App No: AL/21/20/OUT
Address: Land North of Lee's Yard Lidsey Road Woodgate PO20 3SU
Proposal: Outline application with some matters reserved for the erection of 38 No. dwellings consisting of 5 No. 4-bed house, 14 No. 3-bed houses & 19 No. 2-bed houses, with communal work hub & associated car parking & landscaping (resubmission following AL/57/18/OUT). This application is a Departure from the Development Plan.

Liz Annalls
Environment Officer
Environmental Protection
Chichester District Council

Site Habitat Plan

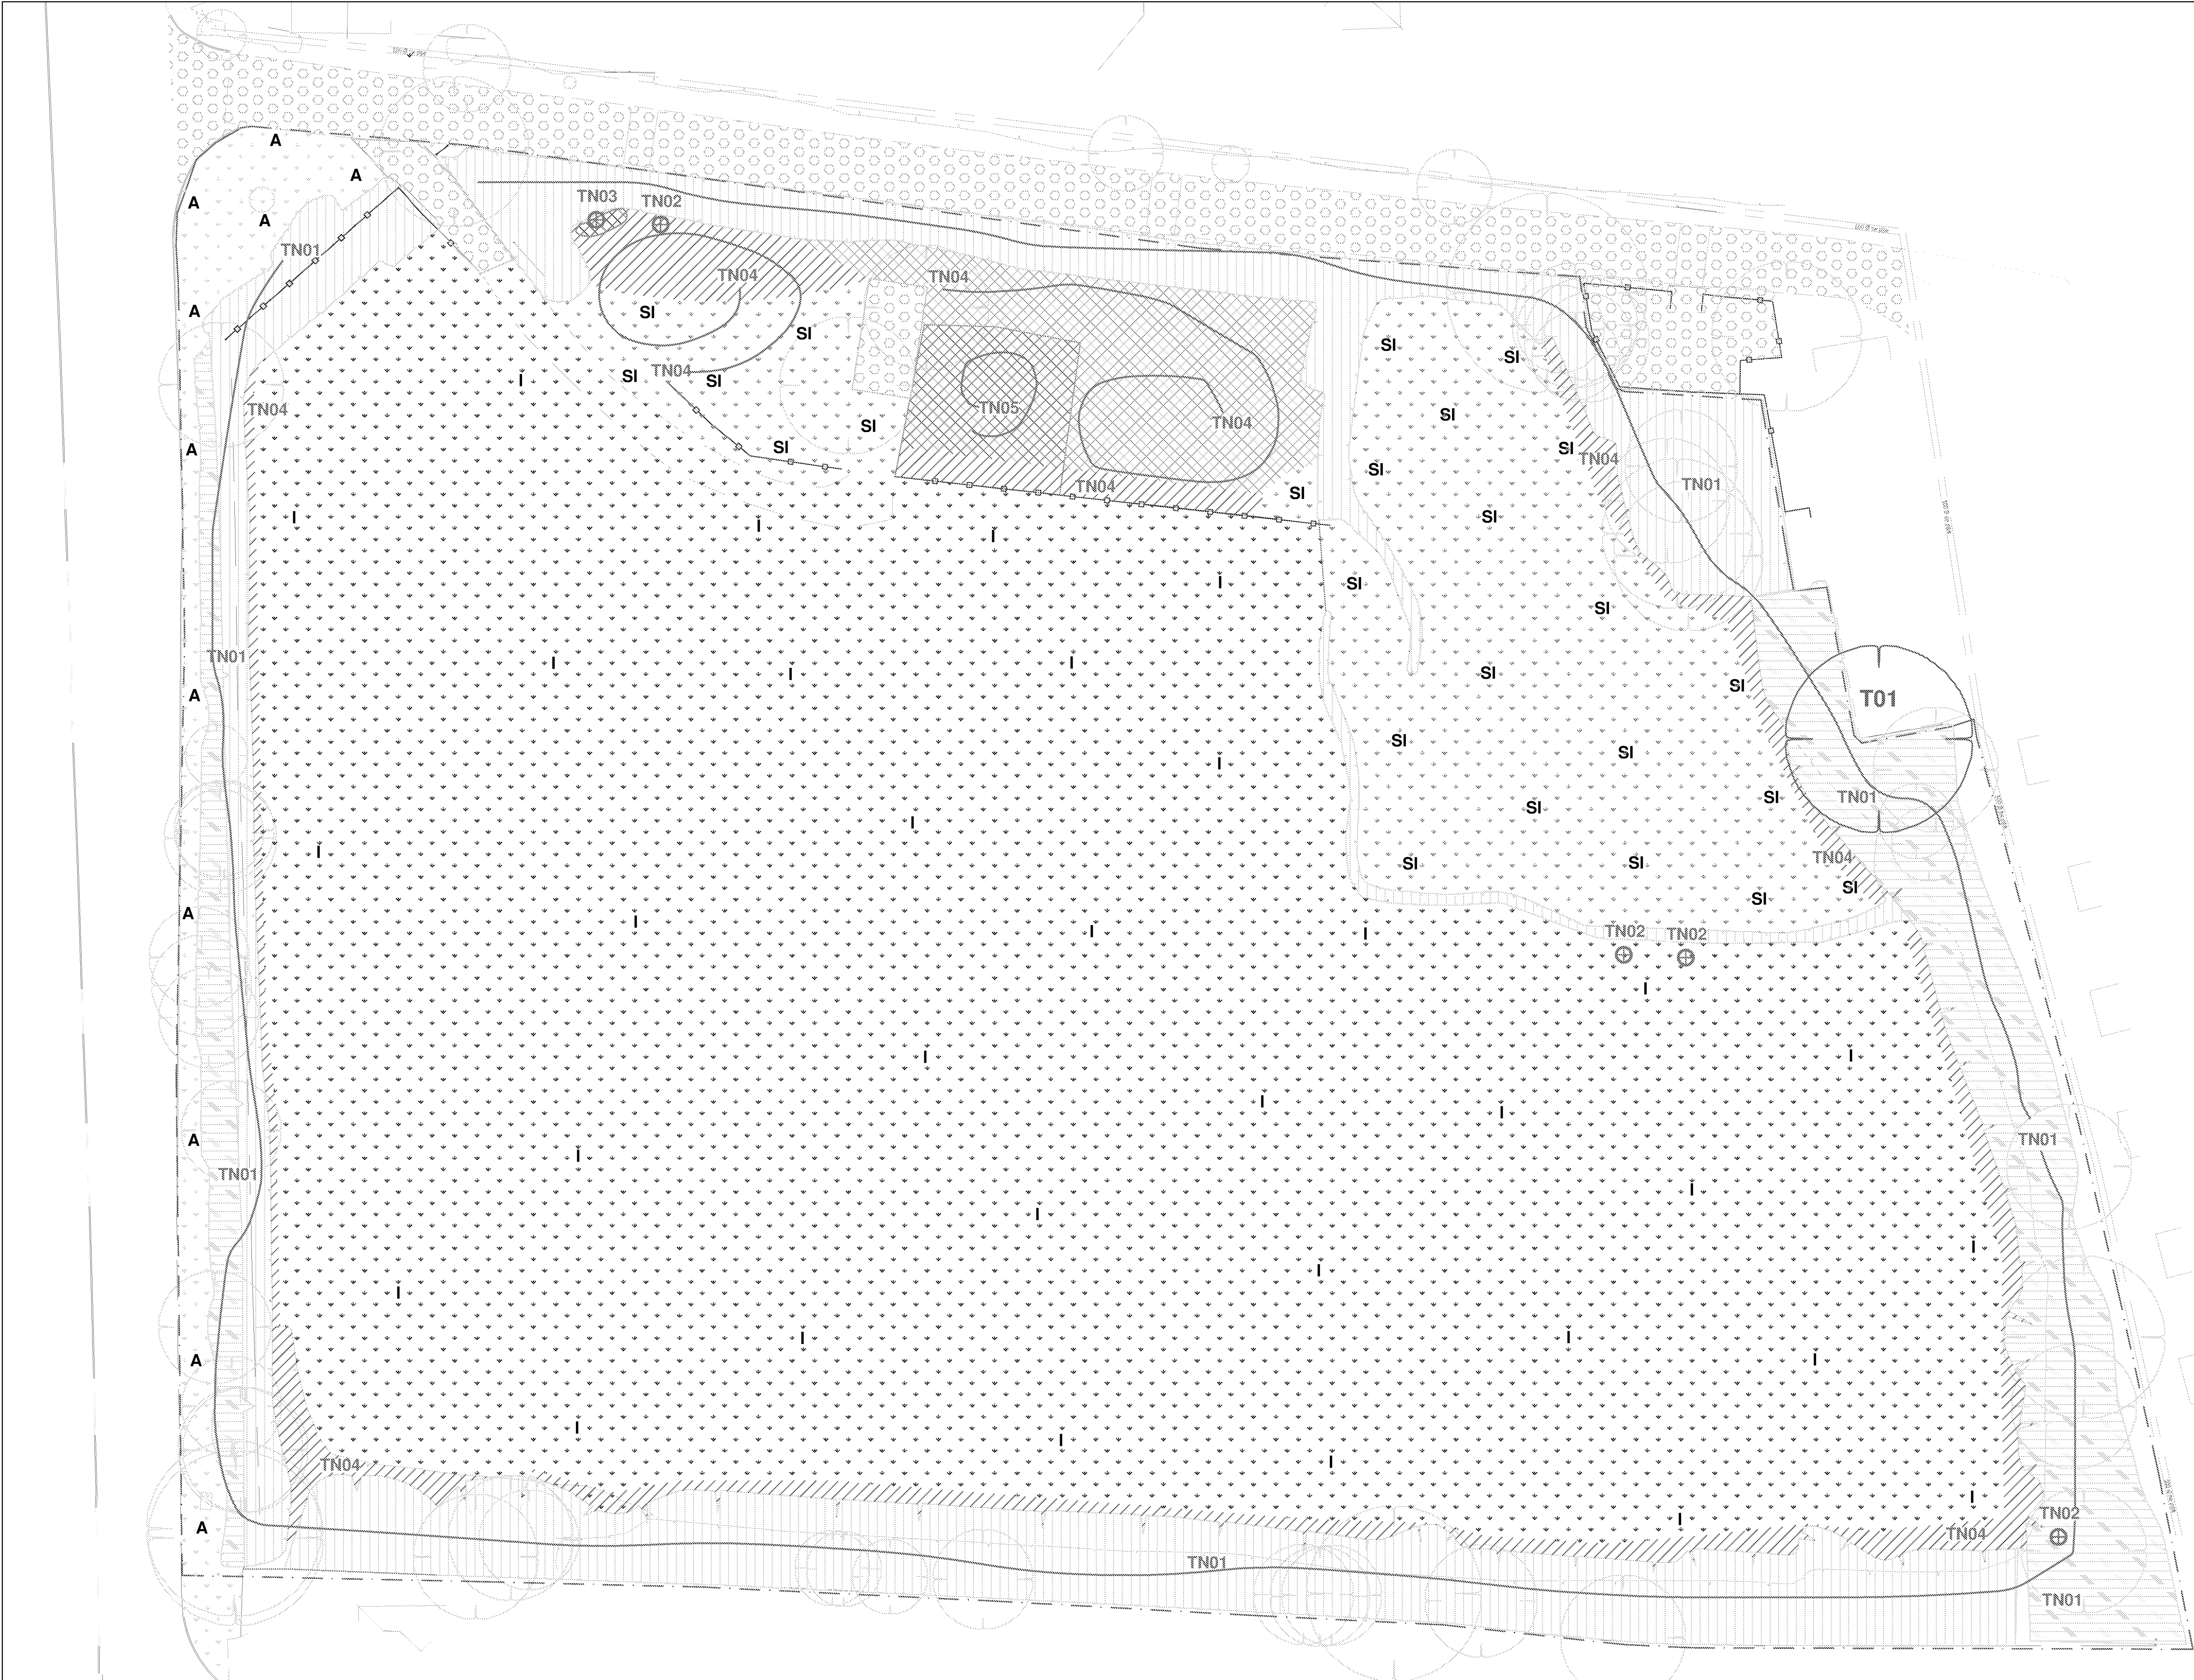
Tree T01 onsite has potential for bats, current plans show that this tree is being retained, however if this changes a bat survey may be required.

The lighting scheme for the site will need to take into consideration the presence of bats in the local area and the scheme should minimise potential impacts to any bats using the trees, hedgerows and buildings by avoiding unnecessary artificial light spill through the use of directional light sources and shielding.
